Rezoning Transportation Analysis

Petition Number: 2021-090

Date	Description
8-20-2021	First Review (DBS)

The site is located on a major thoroughfare, Mallard Creek Road. A Traffic Impact Study (TIS) is not needed for this site. Site plan revisions are needed to meet ordinance requirements and the outstanding items include, but are not limited to, reducing the right-of-way dedication to 2 feet behind the proposed multi-use path and including an 8 foot planting strip adjacent to Mallard Creek Road with a 12 foot multi-use path to accommodate pedestrians and bicyclists. Further details are listed below.

SHEET NUMBER
RZ101

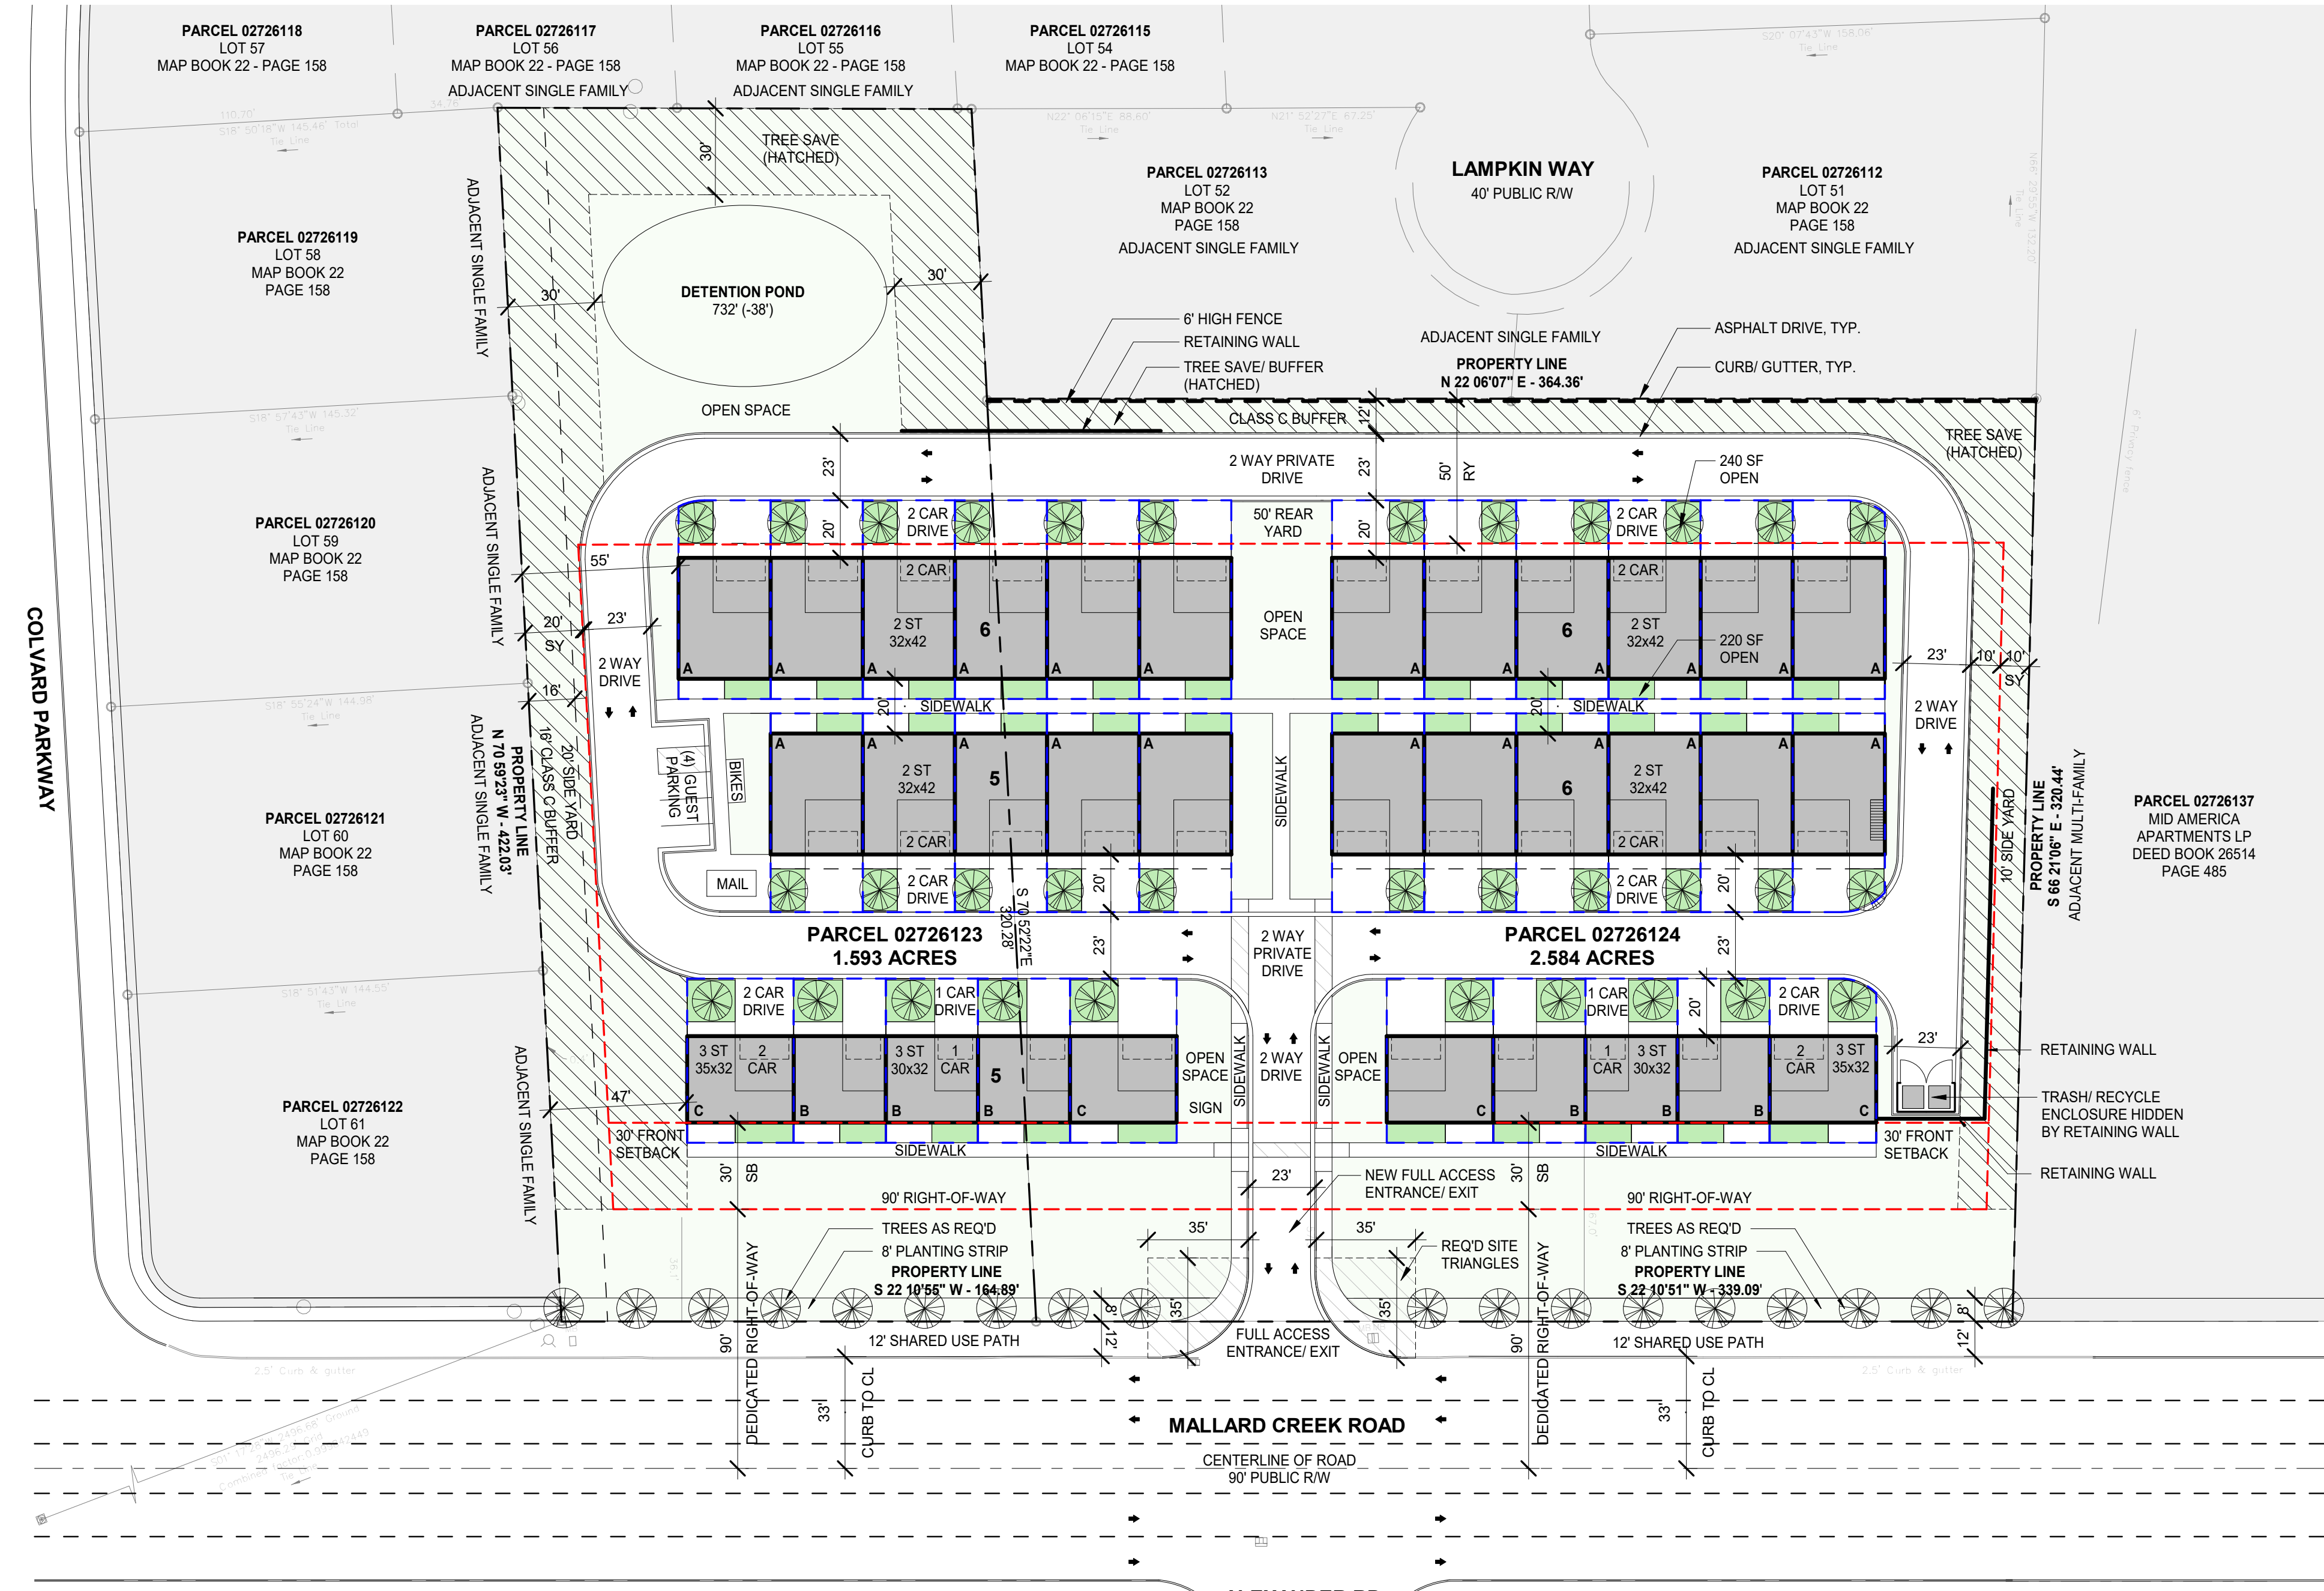
1. A Traffic Impact Study (TIS) is not necessary for the complete review of this petition due to the site generating less than 2,500 daily trips. If during the permitting process the site generates more than 2,500 daily trips, a traffic study will be required.
2. The site plan reflects dedicating 90' of right-of-way from the road centerline. Based on the street classification and street/streetscape elements, this right-of-way width is not needed and can be reduced to the distance from the road centerline to 2' behind the back of the shared-use path. Revise site plan to label and dimension the right-of-way from the road centerline based on the above.

Revise site plan to locate the planting strip adjacent to the back of curb and the shared-use path between the planting strip and the site.

3. A site plan note(s) specifying dedication and fee simple conveyance of all rights-of-way to the City before the site's first building certificate of occupancy is issued is needed. As noted above, CDOT requests rights-of-way be set at 2 feet behind the back of shared-use path where feasible.
4. All public roadway improvements will be subject to the standards and criteria of CDOT and NCDOT, as applicable, to the roadway improvements within their respective road system authority. It is understood that such improvements may be undertaken by the Petitioner on its own or in conjunction with other development or roadway projects taking place within the broad north central Mecklenburg area, by way of a private/public partnership effort or other public sector project support.
